CITY OF ALBUQUERQUE

**Re: SW Positioning, Inc., 609 Osuna Rd NE
Engineer's Stamp dated 10-11-2012 (E16/D031)**

GRADING & DRAINAGE PLAN

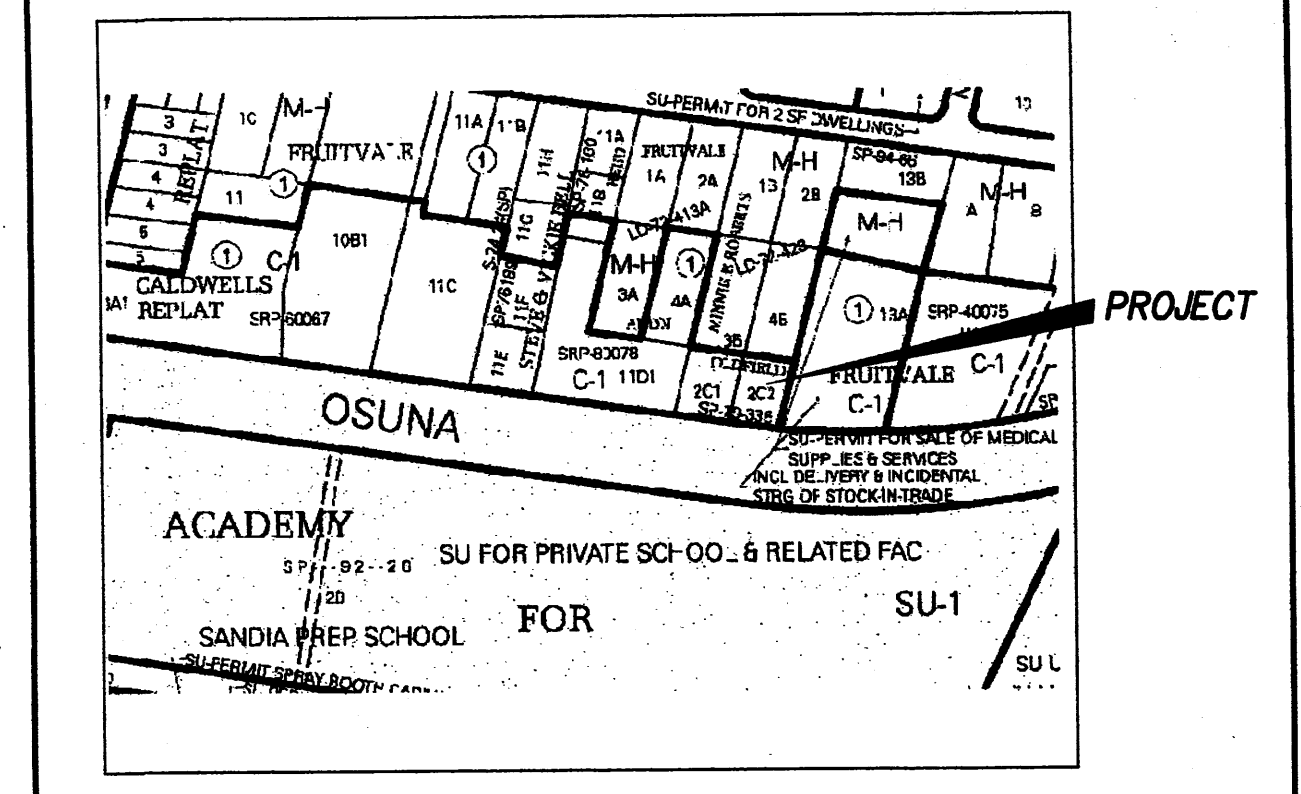
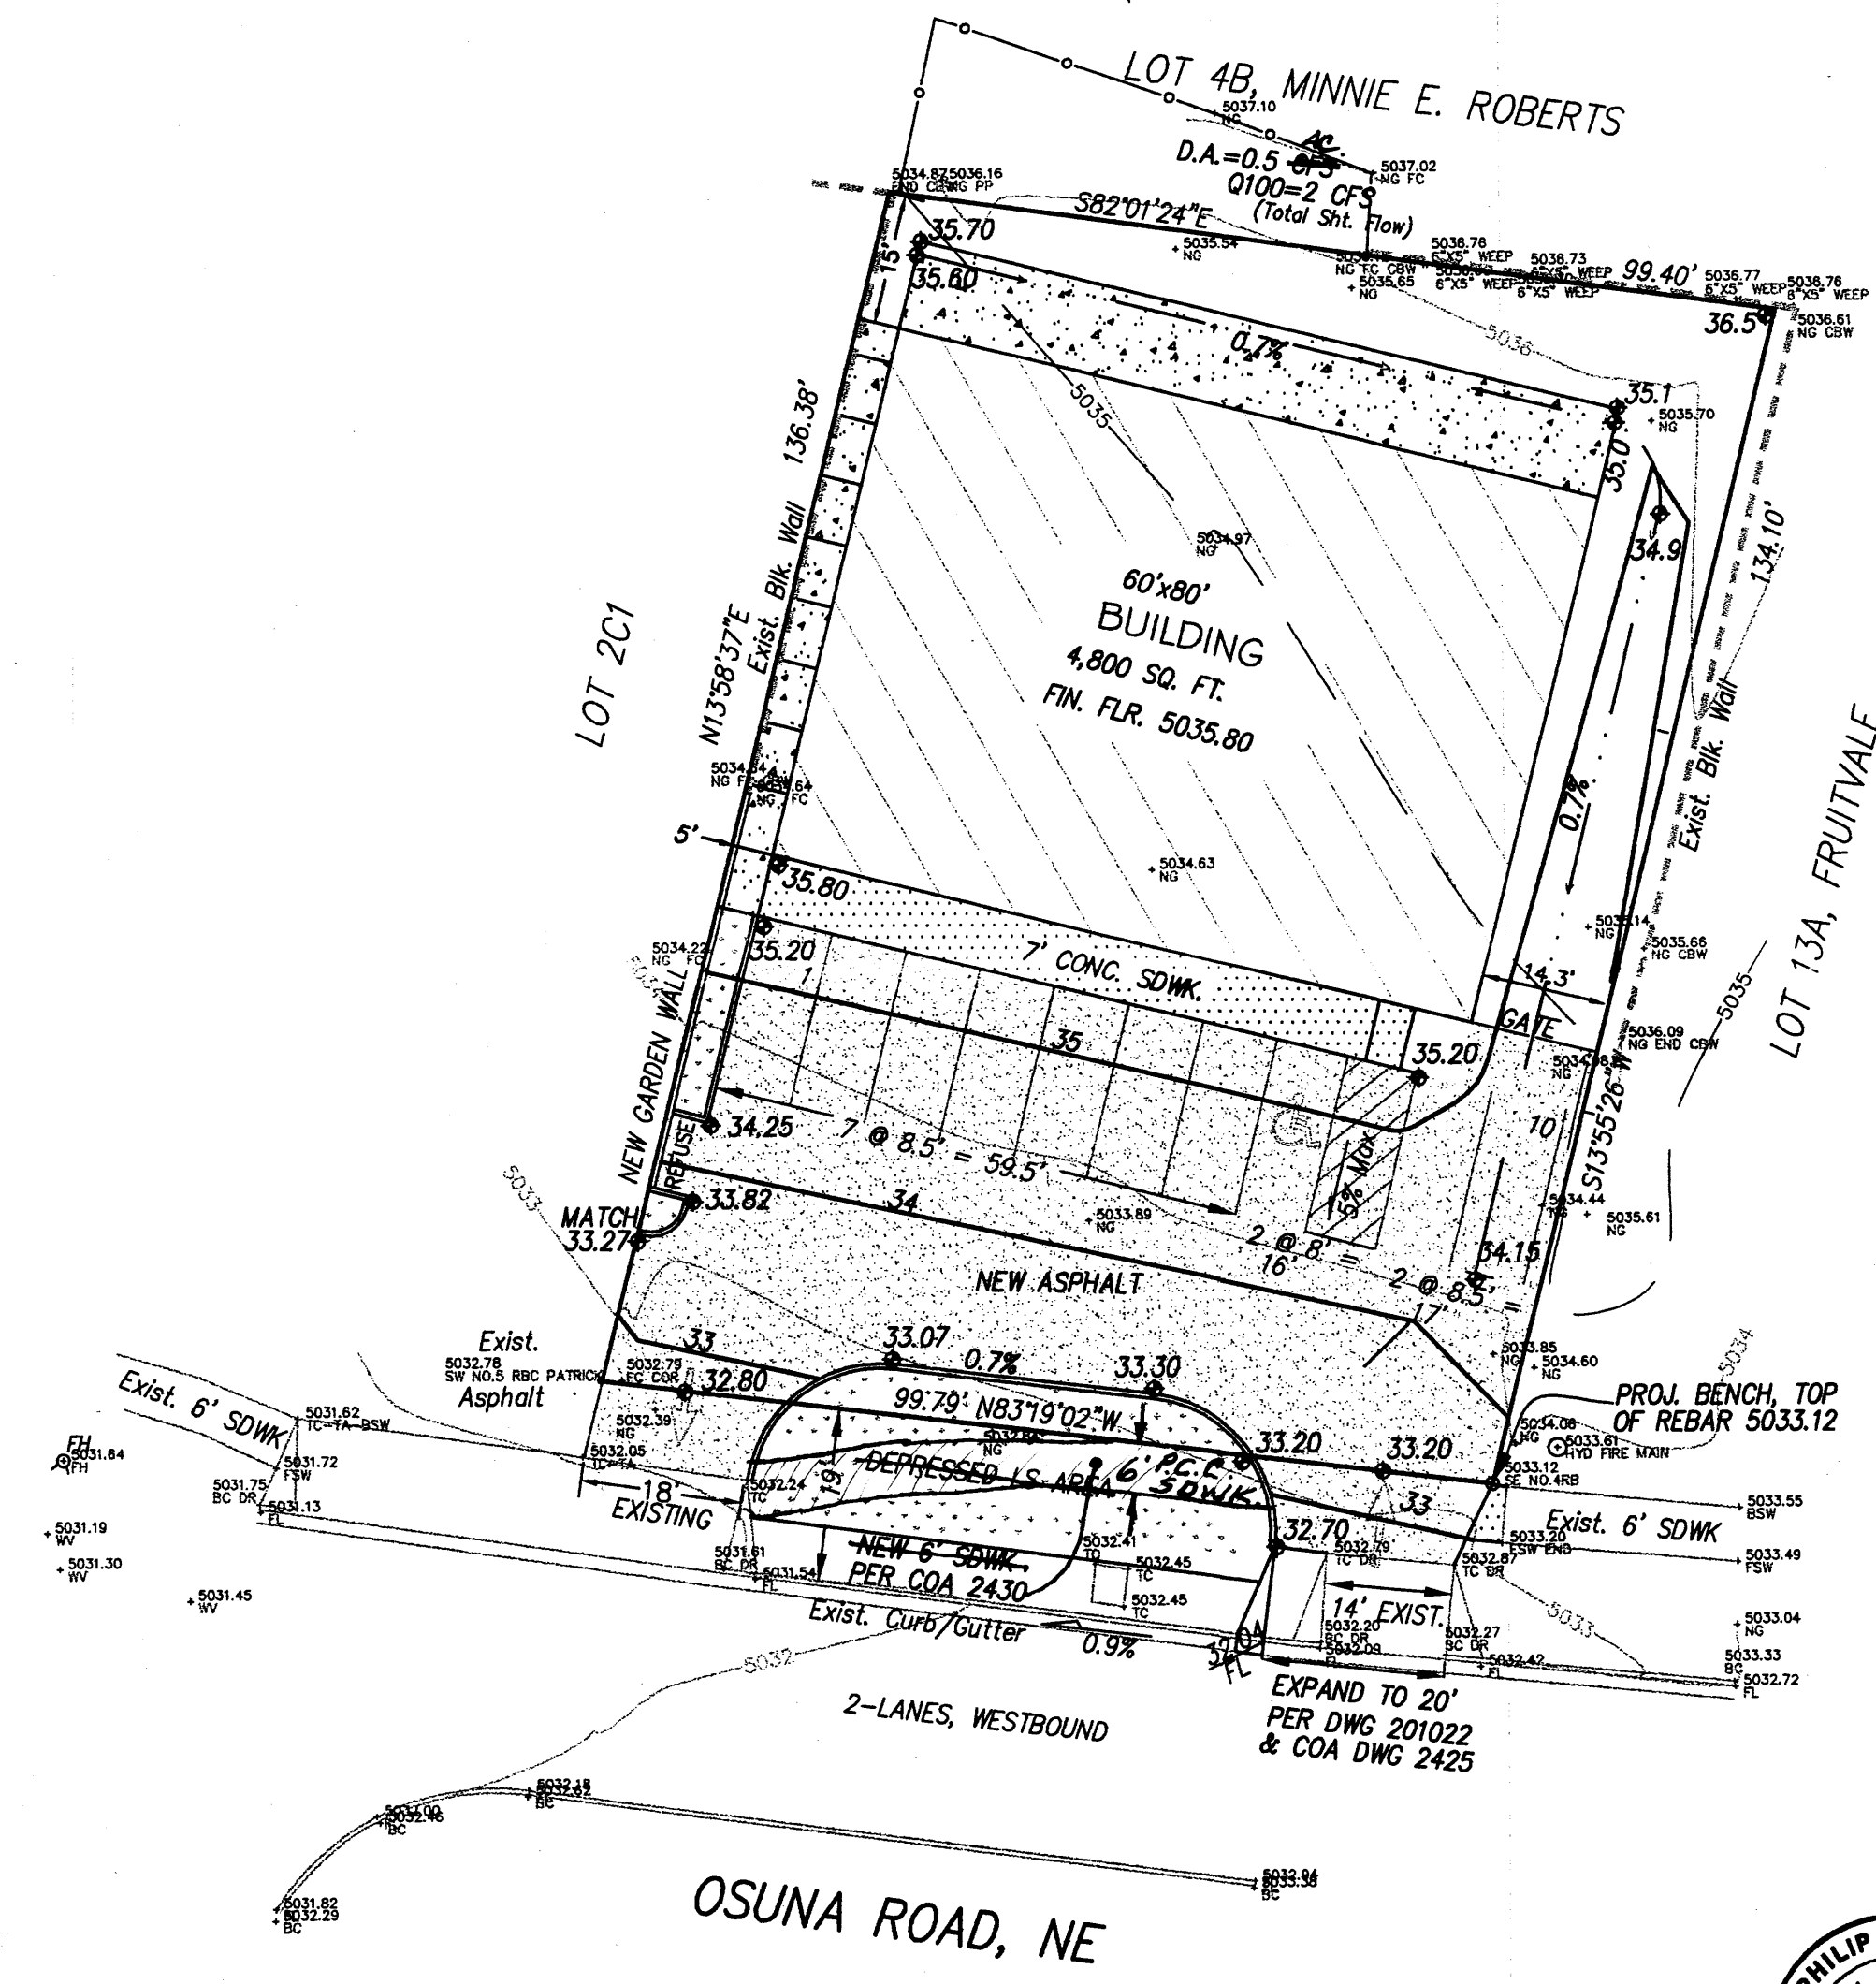
The grading and drainage plan was submitted on 10-15-2012. Sidewalk was modified, and the depressed landscaping area within the ROW was removed and marked on the original plan on 10/26/2012 by Mr. Clark. Based on these modifications on the original, the Plan is approved for the proposed discharge into Osuna ROW.
